## **Gatwick Airport Northern Runway Project**

Examination Ref: TR020005

# **Joint local Authorities Response to the Applicants Deadline 5 Submissions**

Deadline 6: 26 June 2024

Appendix A – NRP Temporary Compounds and Construction Vehicle (HGV) Access Routes

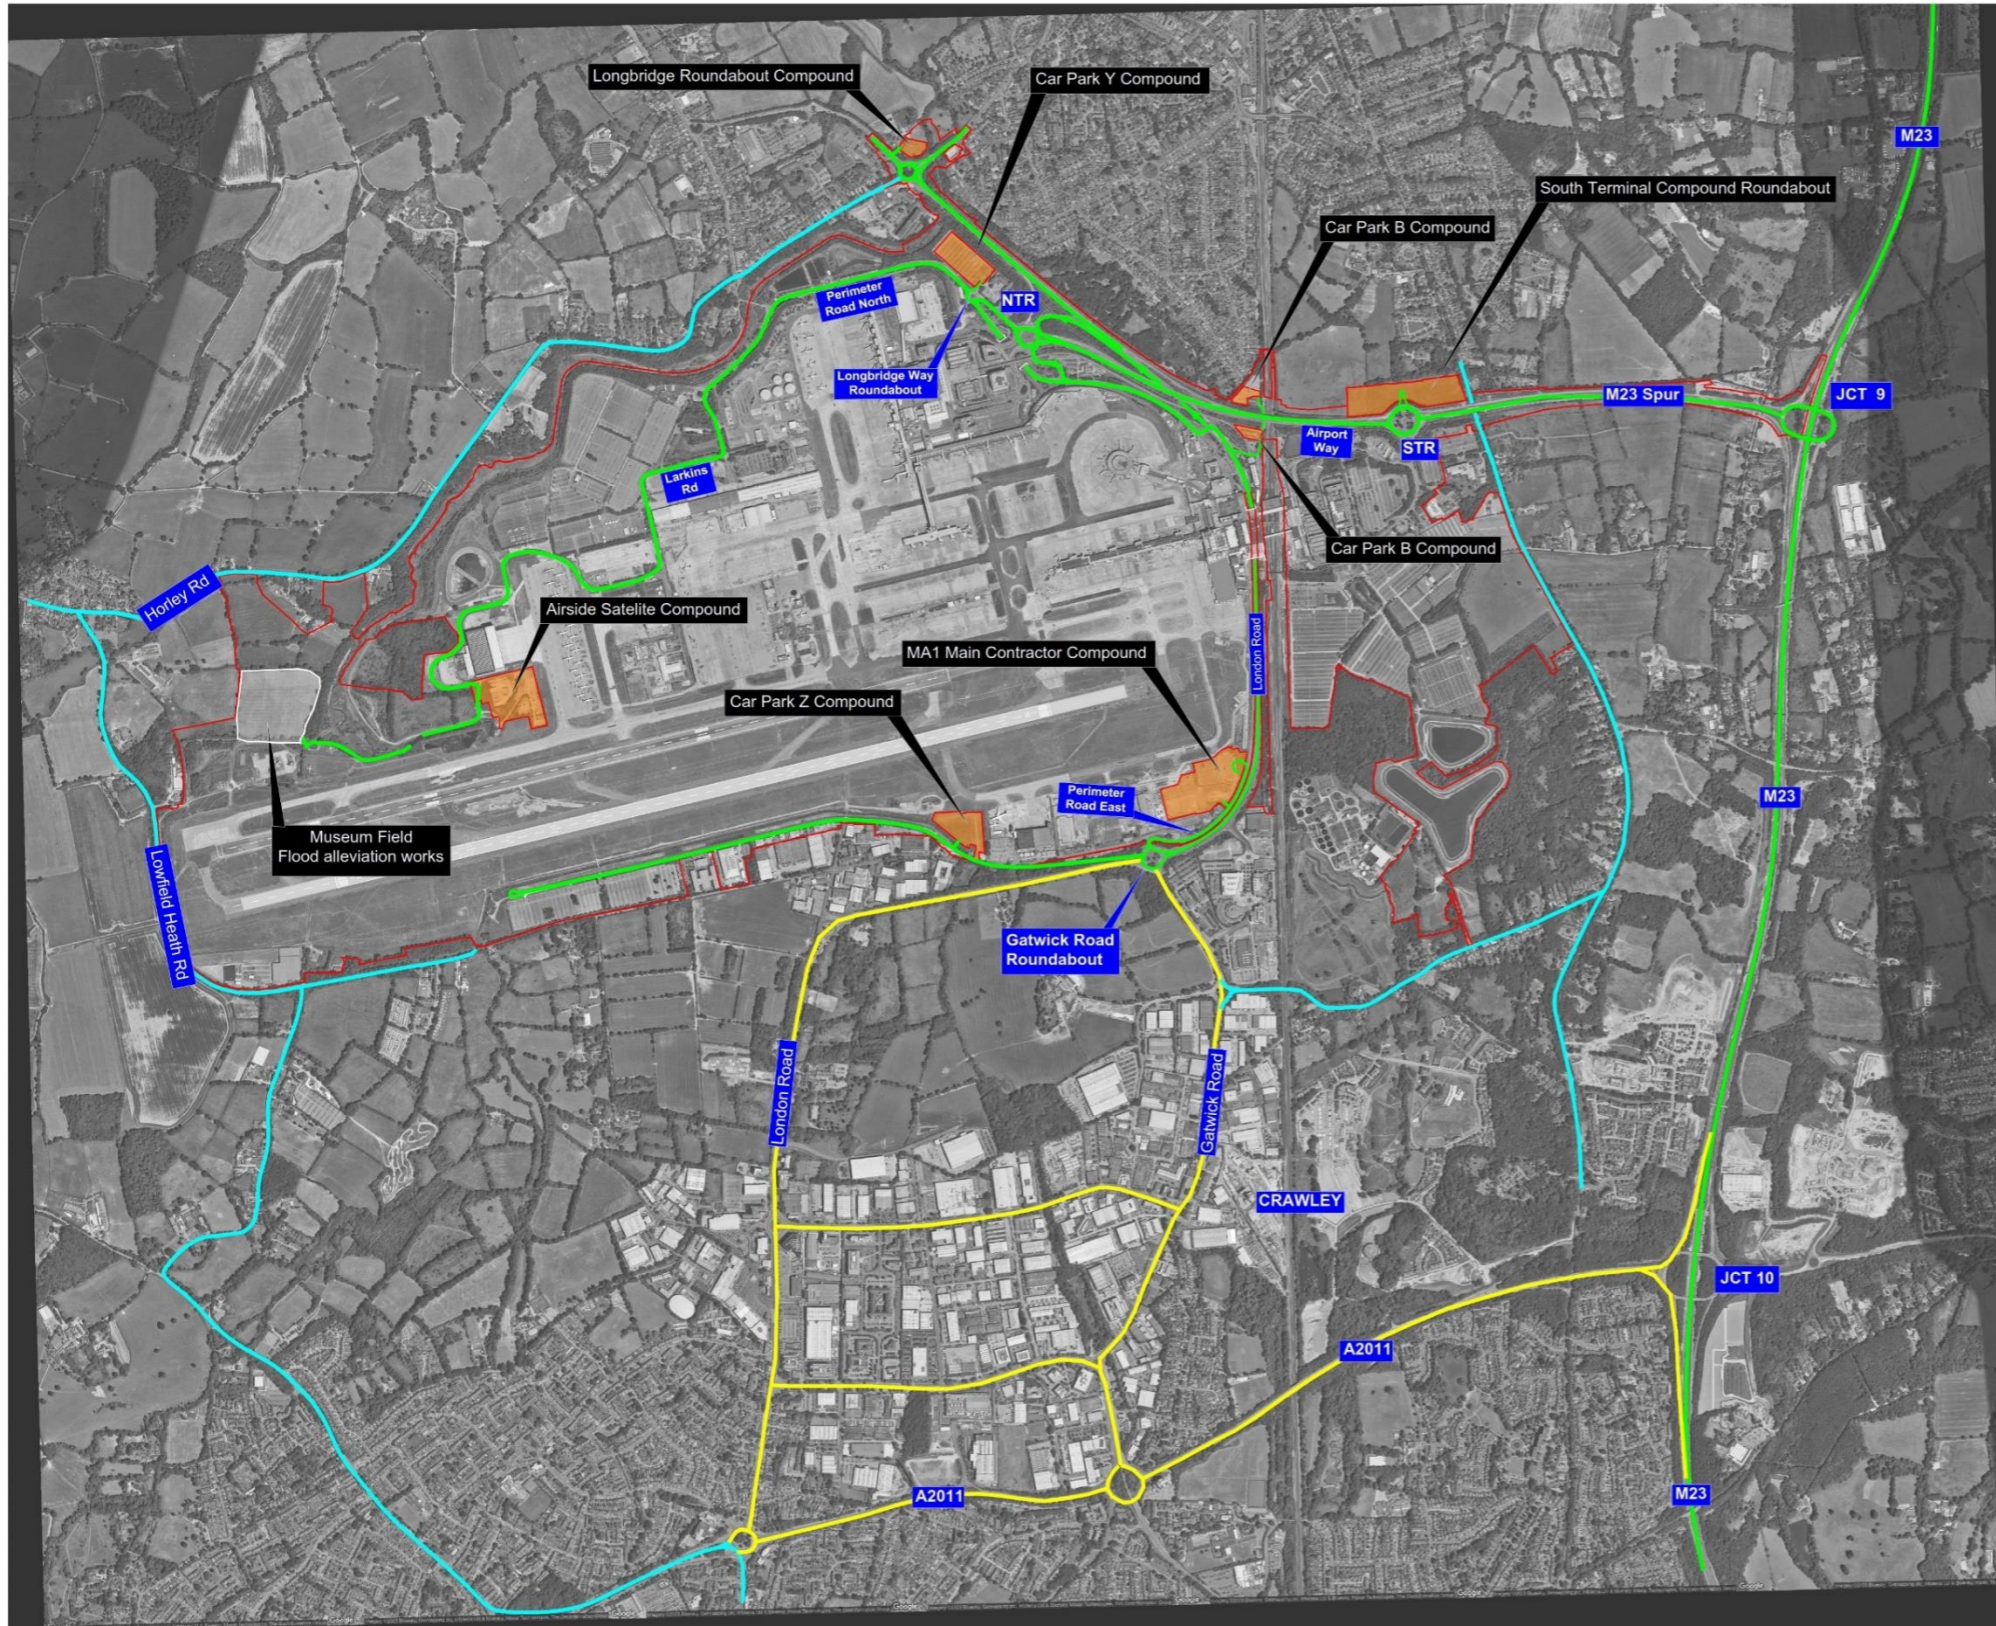
- 2.1 Para 5.1.2 - The contractor construction compounds are shown in Appendix A. However, there is no location information shown for off-airport construction compounds (such as the Reedbed construction site) or for the on-airport Wastewater Treatment Works (WWTW).
- 2.2 Since all the construction compounds are part of the DCO application and the provisions of the oCTMP are relevant to all of the sites, the oCTMP should be amended to show where these sites are.
